4th July 2019

Single storey rear extension and single storey front extensions (Amendment to previously approved application AW/307/18/HH). This application affects the character and appearance of Craigwell House Conservation Area
19 Kingsway Aldwick

Thank you for your internet representation made on 3rd July 2019 which has been recorded as '**an objection**' with the comments as follows:

Front Elevation

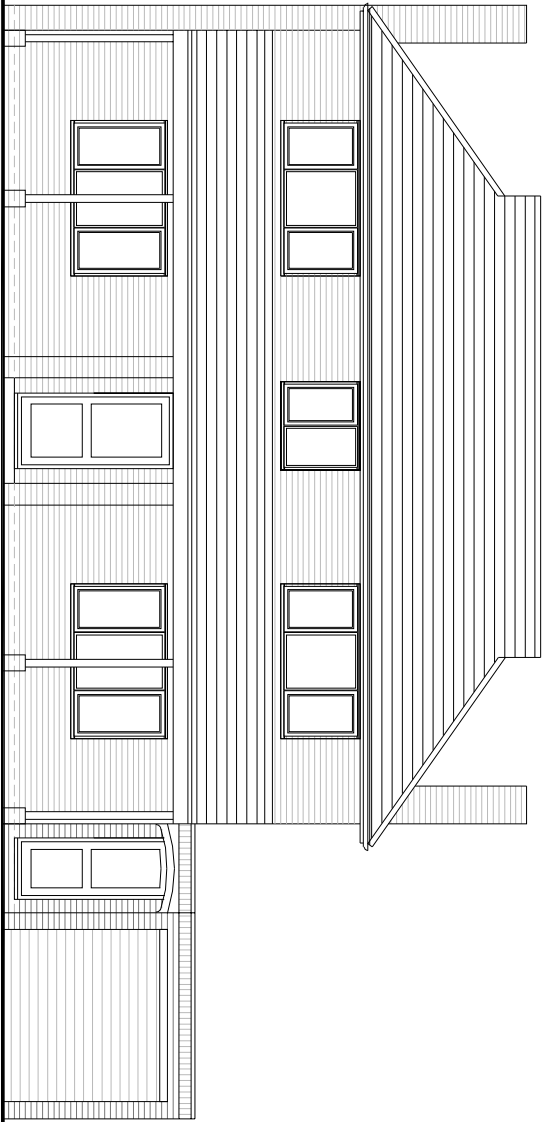
By reason of its extent and poor design the proposed front extension will appear incongruous in the street scene and will detract from the character and appearance of the conservation area. If approved it could set a precedent for similar extensions in the remainder of the street which would cause further harm to the Conservation Area. The proposal therefore conflicts with the relevant paragraphs of the NPPF 2019 and policies contained in the ADC local plan 2018 relating to the protection of conservation areas and good design.
